22 December 2021
Covering letter - 22 December 2021

**39207/APP/2021/3967- DISCHARGE OF CONDITIONS 4 AND 7
GSK, STOCKLEY PARK, IRON BRIDGE ROAD, WEST DRAYTON**

Tree Protection Drawing

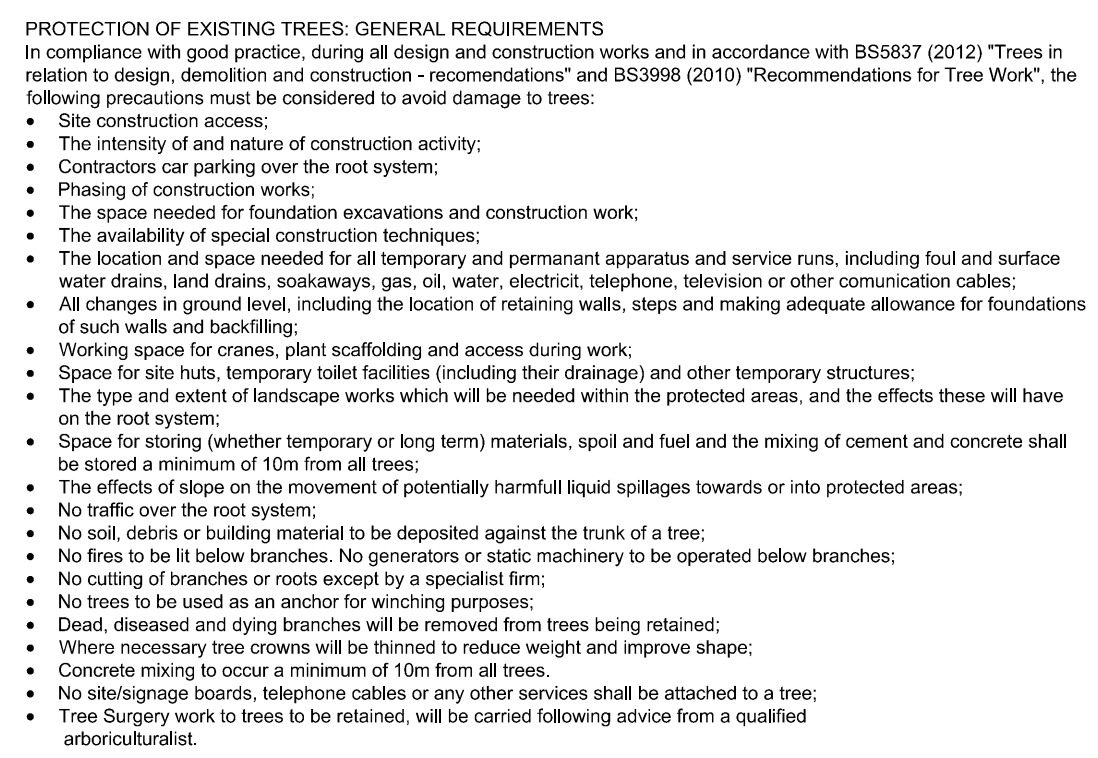
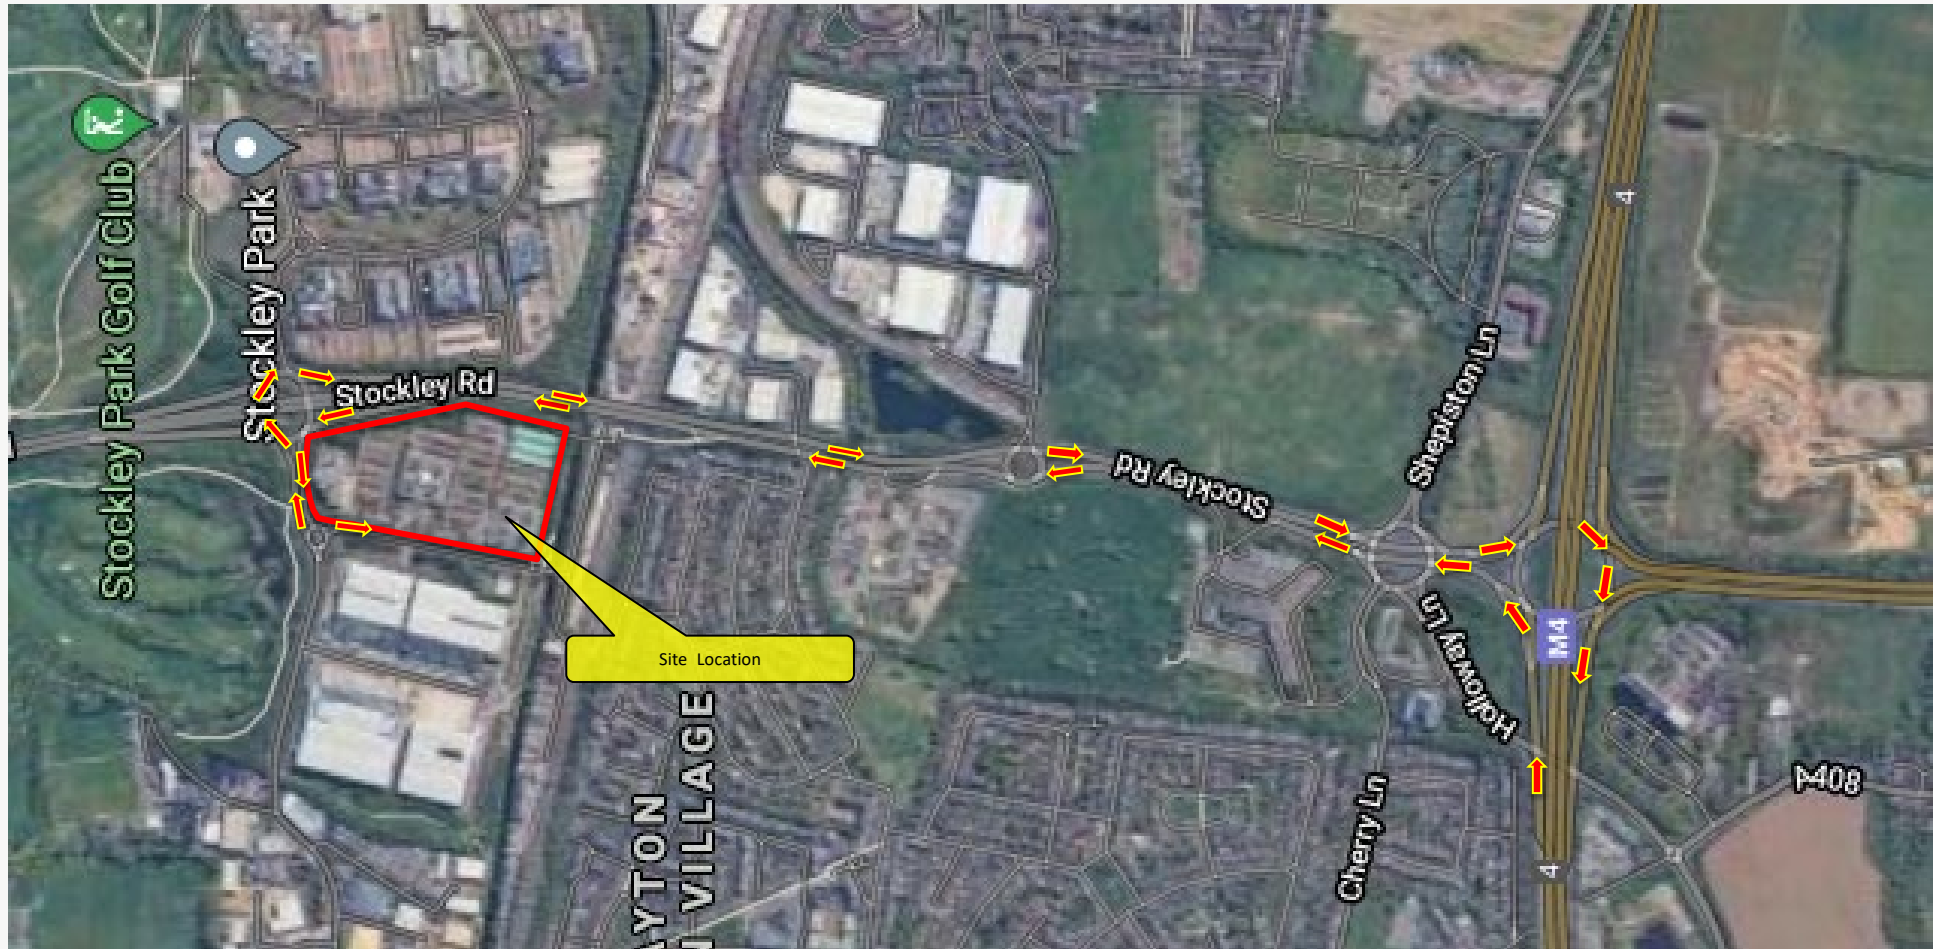
In respect of Condition 7, tree protection measures are required across the site, and these details do not appear to have been submitted, however, prior to any demolition works, tree protection measures should be submitted for approval. As such, the demolition management plan should refer to and incorporate the tree protection measures and further details are required prior to approval."

- Method Statement (inclusive of a tree protection plan);
- Updated Demolition Plan.
